## Beacon Fen Energy Park – Development Consent Order

Application reference: EN010151

Document: Deadline 6 – Response to Low Carbon’s Technical Note prepared in response to CAH1

### Executive summary (LCJM D6 response to Applicant’s Appendix 1 / CAH1 Action No. 2)

ExD6.4 Diagram showing 833 metres across [redacted] land [green line]

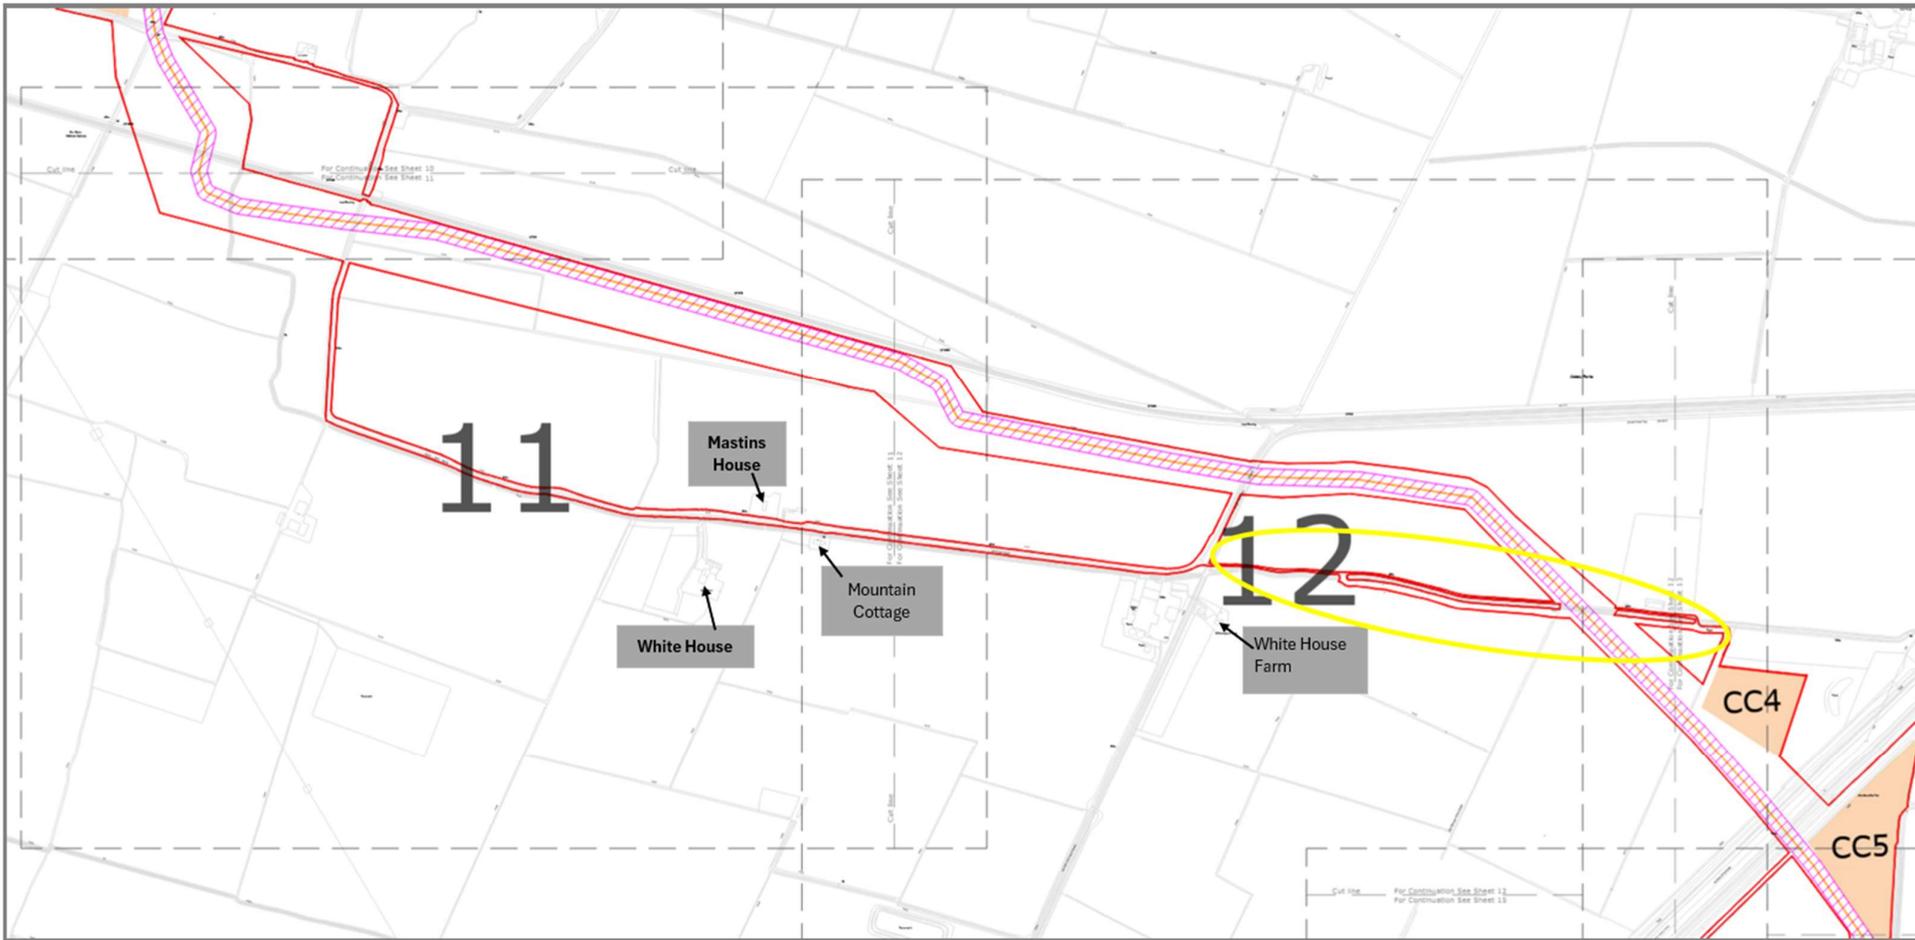
5.5.2 That conclusion fails if the route length input is wrong – **Ex D6.8**. LCJM’s measured length evidence indicates the LCJM Hybrid is shorter, so the Applicant’s §2.3.17 conclusion should be given limited weight unless Row 1 is corrected and the length methodology disclosed. Furthermore, if not “collecting” all LCJM’s Aug 2023 618 PV and BESS acres via the LCJM Hybrid route, then this north / south route could be even shorter by going across ██████████ ██████████ fields on which LCJM is the tenant – **Ex D6.4 [green line]**.

ExD6.6 Diagram showing 1,647 metres of double occupation (north and south – red line below) of LWS 4722

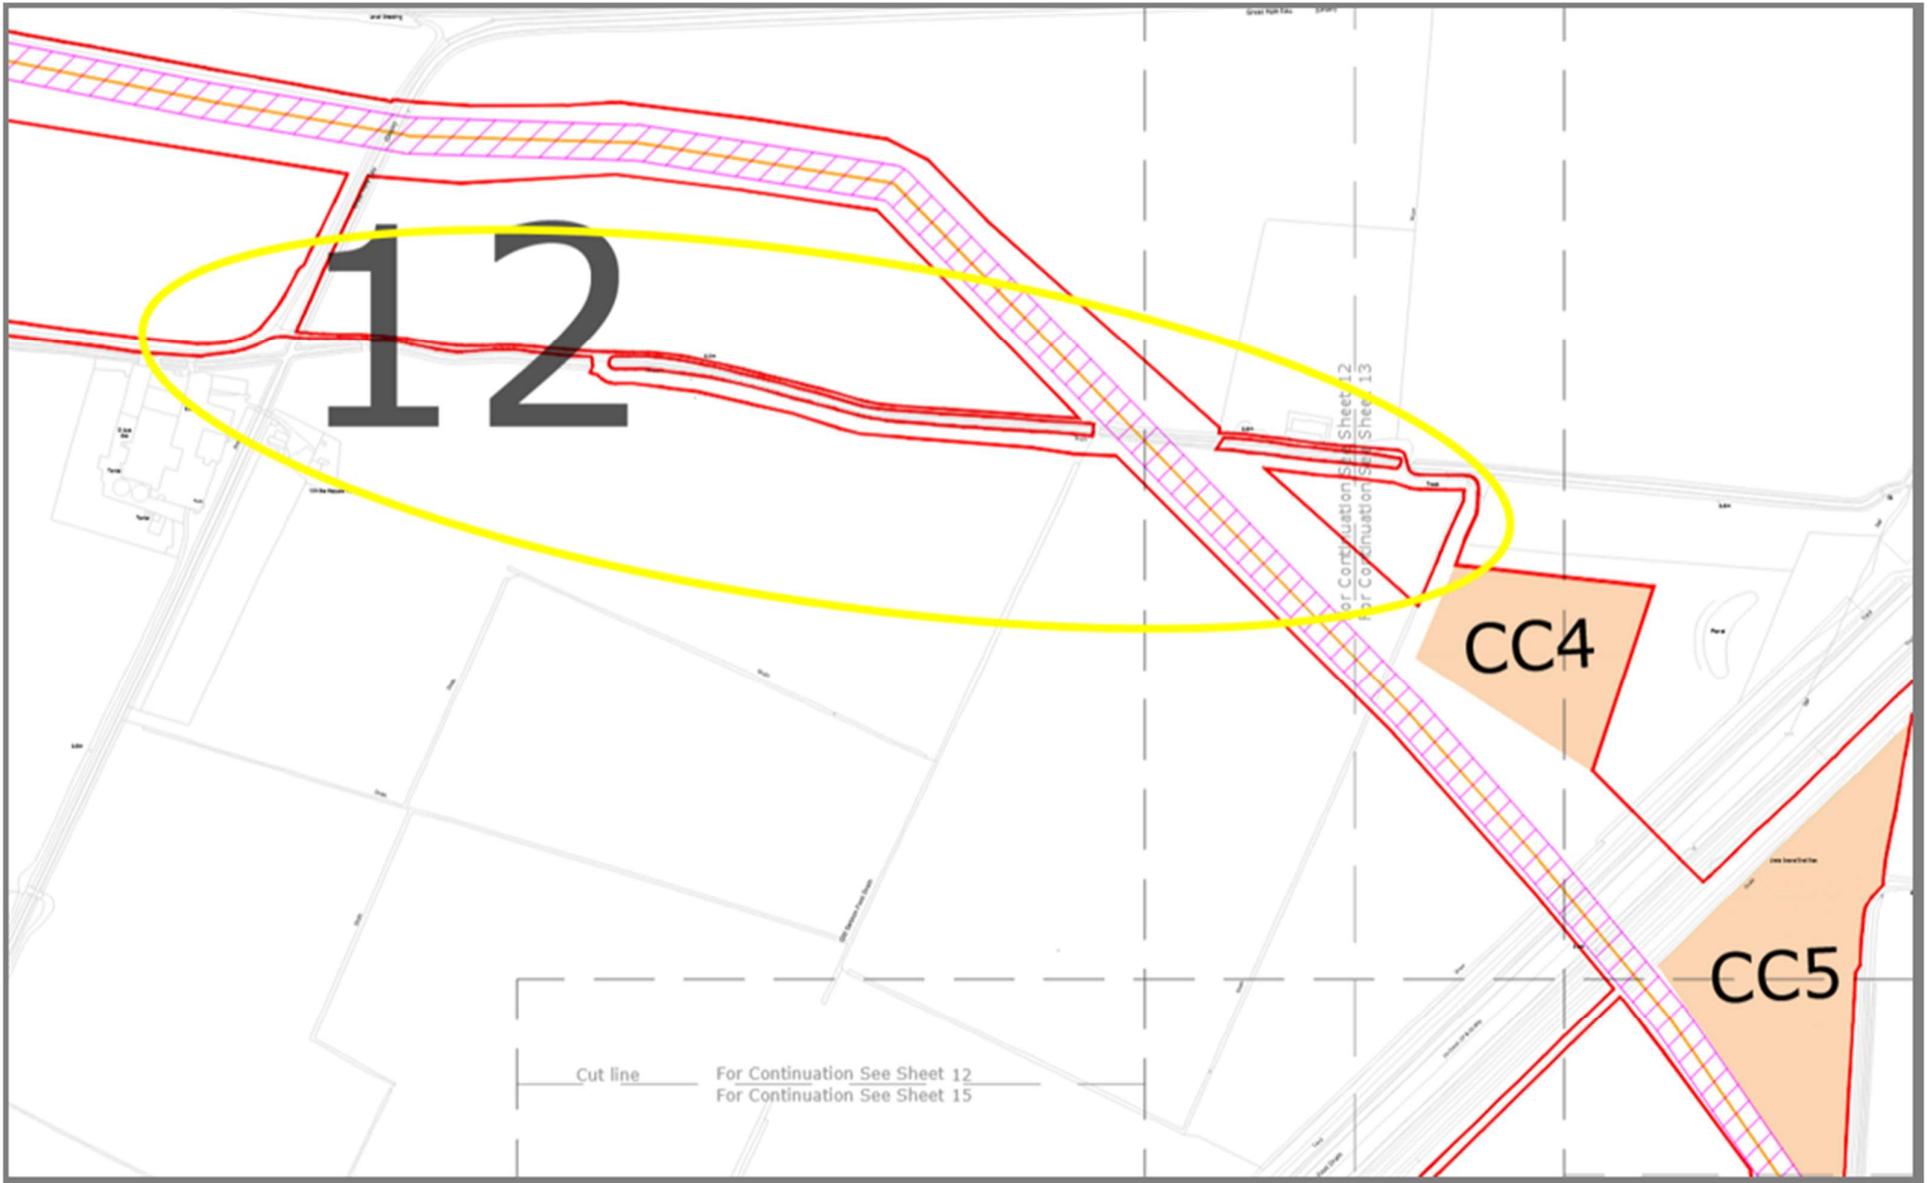
**Ecology/LWS interaction is materially understated by the scope choice.** The Applicant’s own construction logistics assumptions show sustained longitudinal interaction with LWS 4722 (Great Hale Eau) and LCJM’s evidence identifies double occupation north and south totalling 1,647m—a corridor-only method does not capture this properly and the qualitative narrative is not auditable.

**3.9 Sensitive corridors are also suppressed by the chosen scope.** LCJM's concern is not merely "number of crossings", but prolonged longitudinal interaction driven by construction logistics. The Applicant's assumed construction access for Construction Compound 4 runs for approximately 1.18 km longitudinally along Local Wildlife Site (LWS) 4722, i.e. directly on top of the LWS rather than merely intersecting it. Further, LCJM's evidence indicates occupation north and south of LWS 4722 with a total interaction length of 1,647 metres (**Ex D6.6** and **Ex D6.7**). A corridor-only quantitative method does not capture these construction-driven interactions, while the qualitative narrative is not presented in a manner capable of audit or replication.

**EX 6.8** Diagram showing evidence of LCJM Hybrid being at least 32 metres shorter [6,786 metres versus 6,818 metres] than the Beacon Fen cable route and avoiding all north / south drainage every 21 yards in Great Hale Fen on LCJM's fields

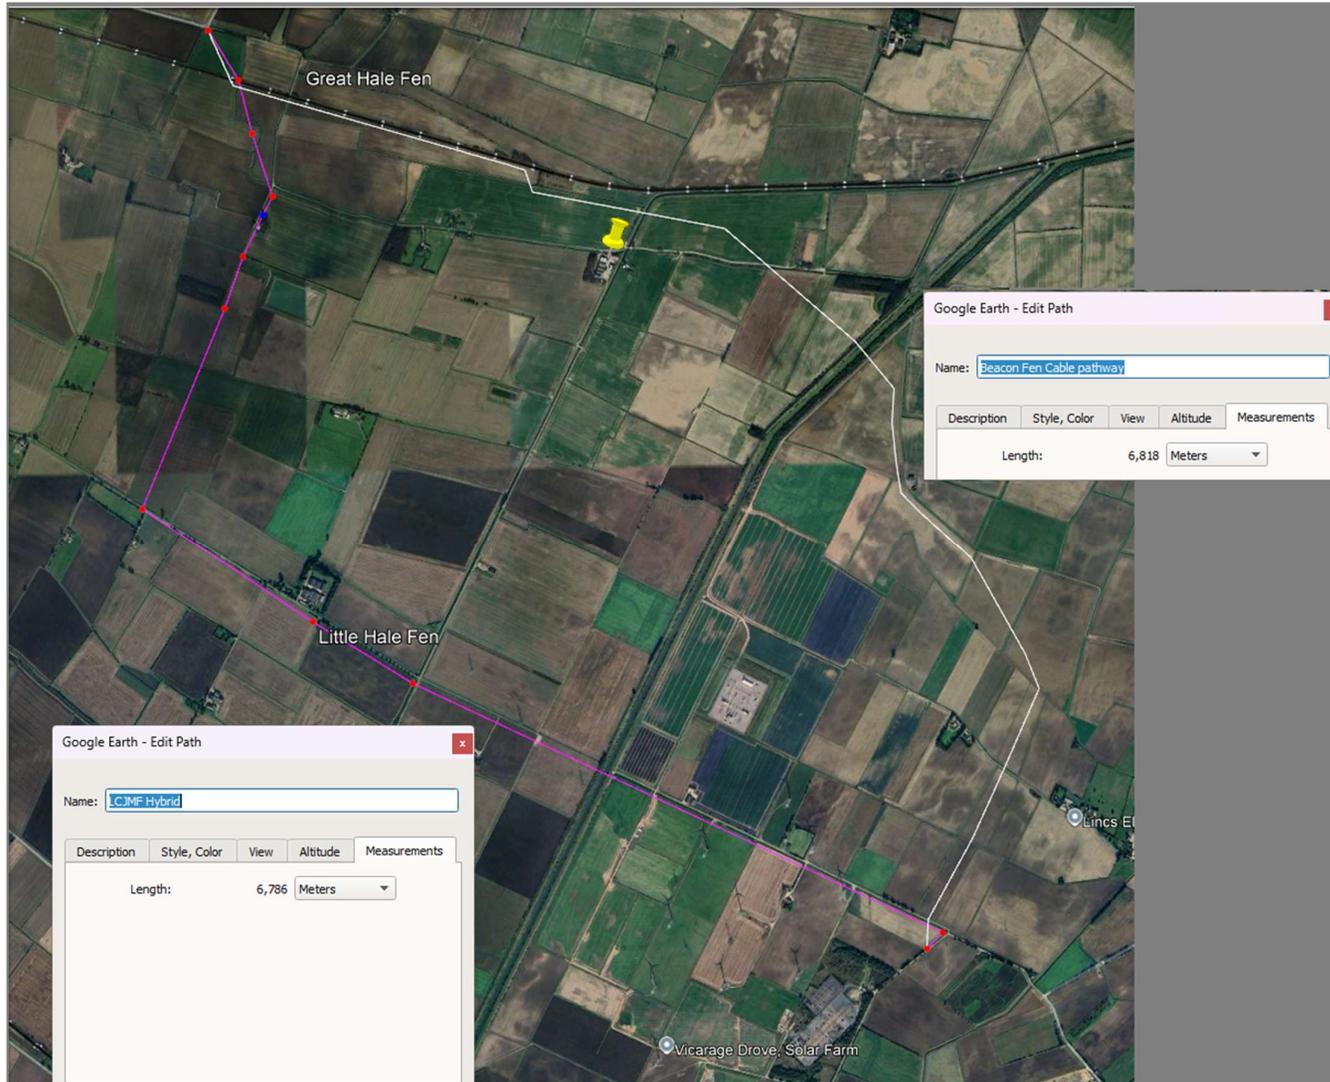
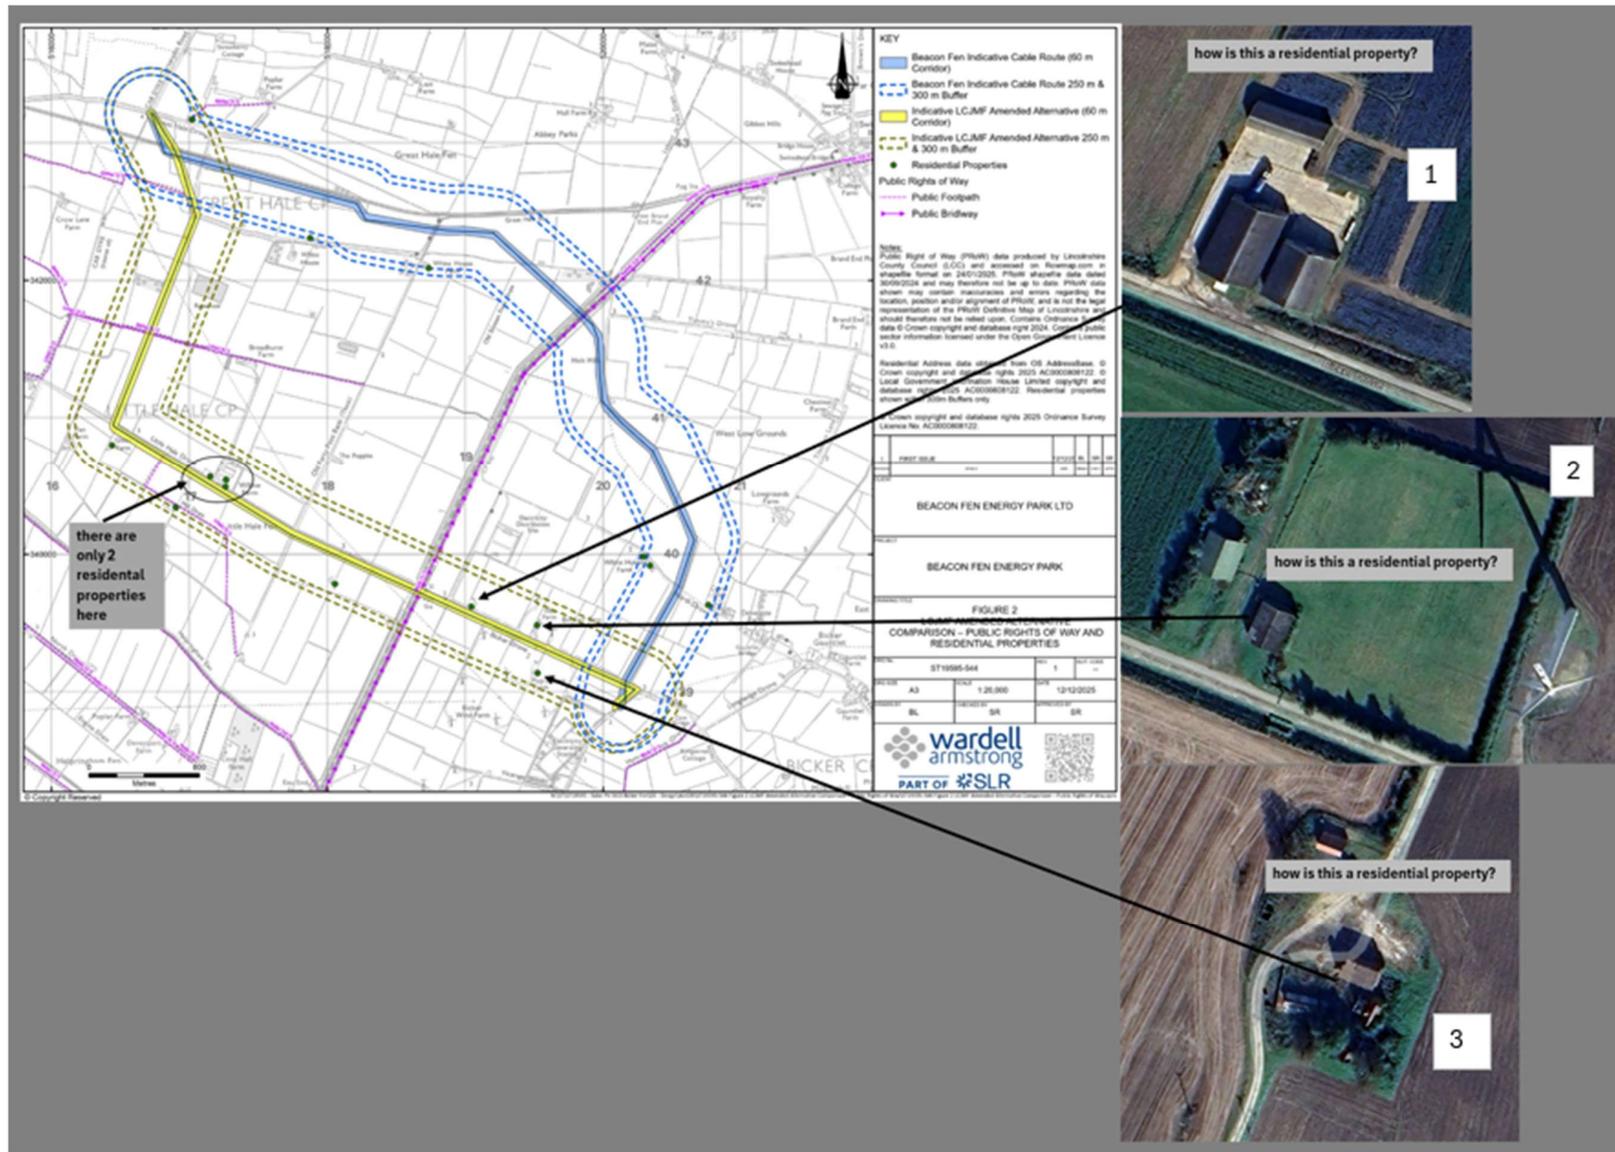
- Row 1 length is wrong and reverses the direction of difference. Using the same endpoints shown by the Applicant, LCJM’s measurement evidence indicates the LCJM Hybrid is shorter (6,786m) than the Beacon Fen route (6,818m), i.e. shorter by 32m, not longer as Table 1 implies.
- Because route length is then used downstream (e.g., climate and “km in ALC bands”), any conclusion that depends on the Applicant’s length input is unsafe unless corrected and auditable.

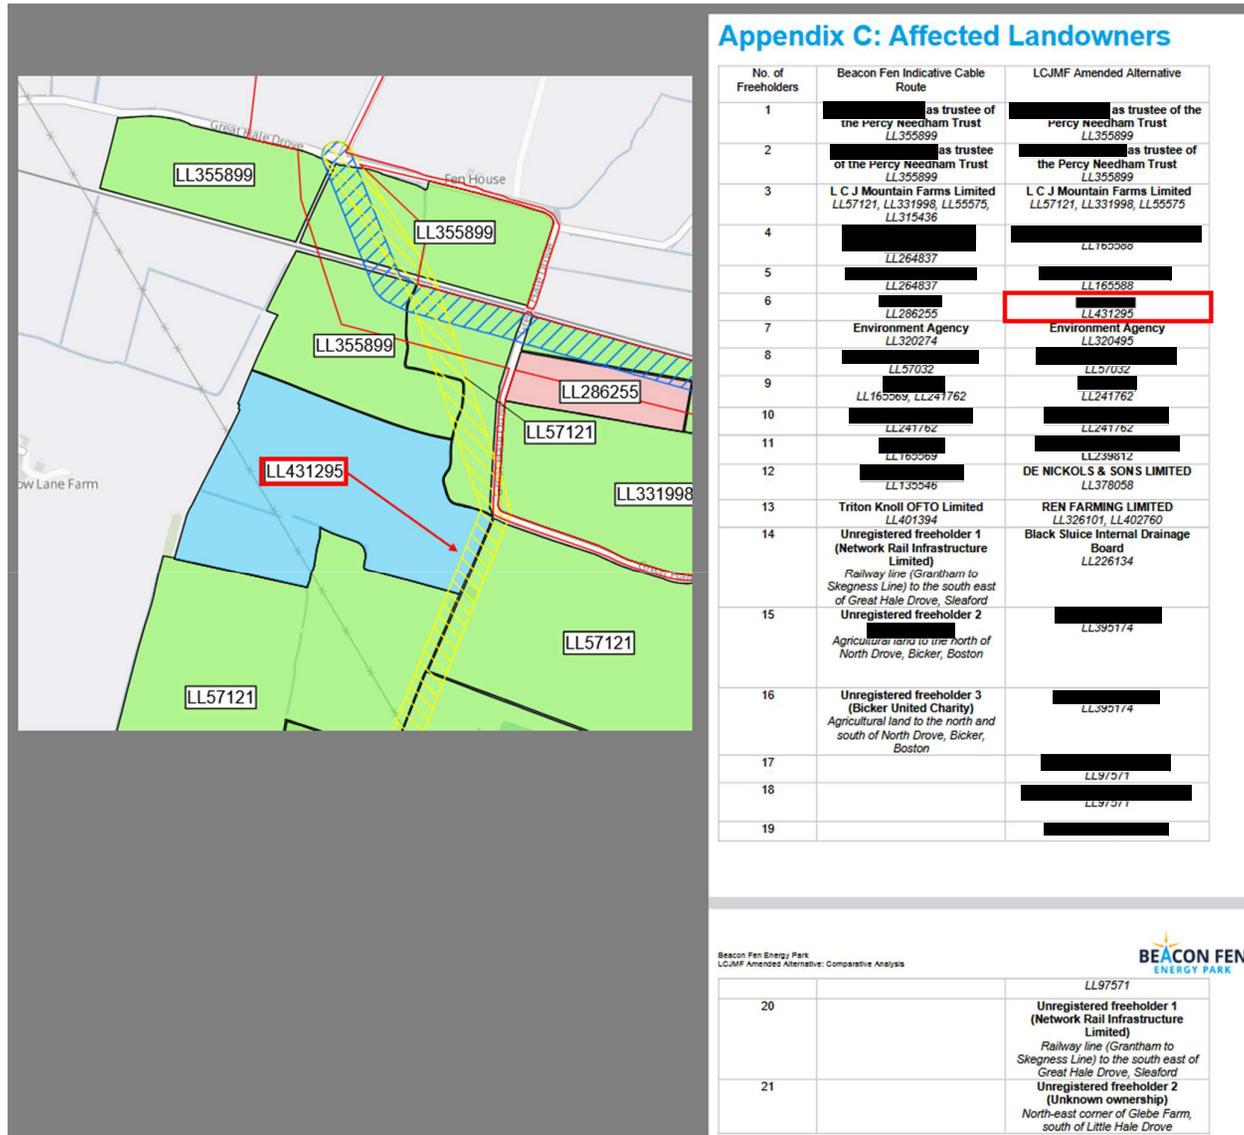
5.6.2 LCJM does not dispute proportionality, but the Applicant’s approach collapses known, evidenced local distinctions [Ex D6.13] into a generic “both are BMV anyway” statement. Appendix 1 itself records that LCJM’s case is founded on (i) a site-specific ALC survey **dated November 2021** on c.200 acres (75 pits) recording ~96% Grade 3a, and (ii) 30 years of cropping records used to place the LCJM Hybrid deliberately onto Grade 3 land.
